Application no: H12-0720-15

Description: Proposed extensions and alterations to dwelling including Solar PV installation to roof

Amendment: Enlarge south extension to 8.1m, increase gable end window to 3m, replace window with sliding patio doors

ACKNOWLEDGEMENT OF AMENDMENT

Mr & Mrs Burr Alterations and Extensions to
GREENWOOD, LUTTON BANK, LUTTON, LINCOLNSHIRE PE12 9LL
Amendment August 2015 PLAN 2 REV 1

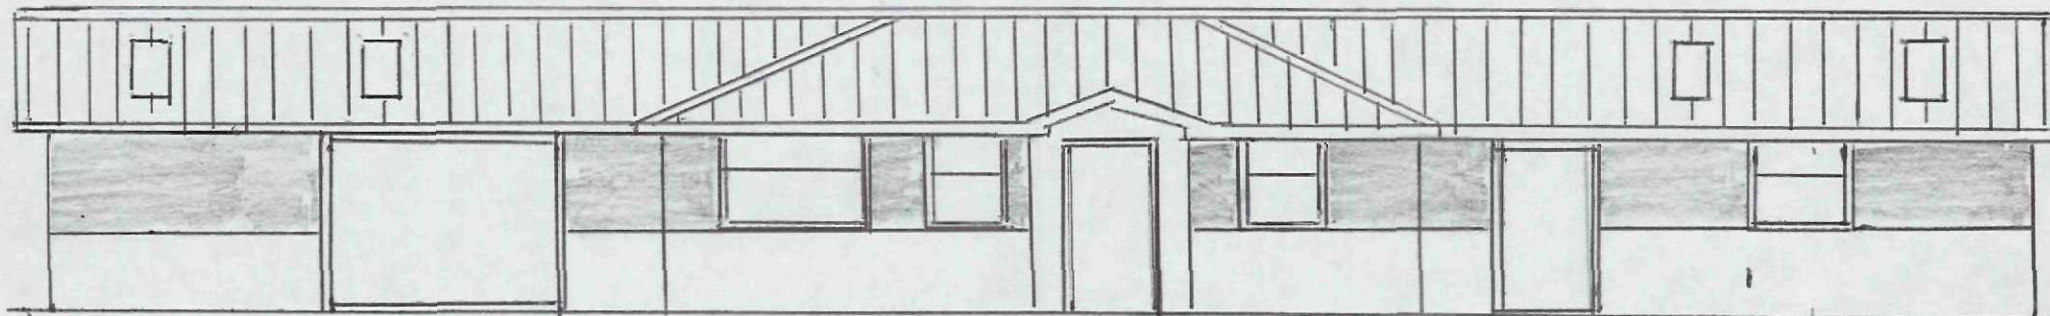
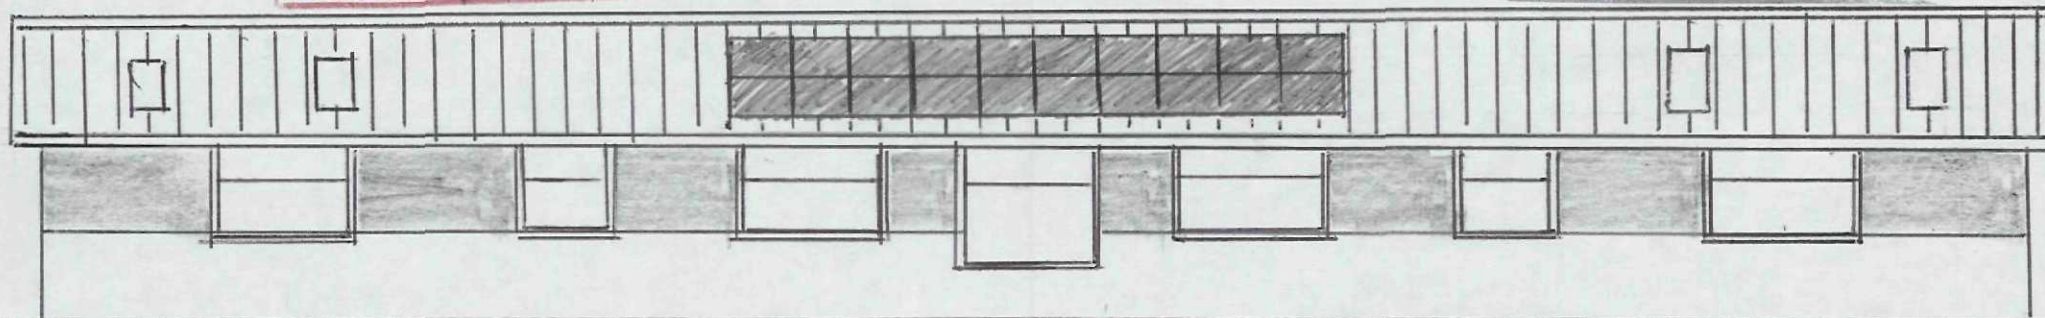
Long Description **- Enlarge south extension to 8.1m to match proposed north extension.
 - Increase window on gable ends to 3m.
 - Remove 120 window from east elevation of south extension replace with 300 sliding patio doors.**
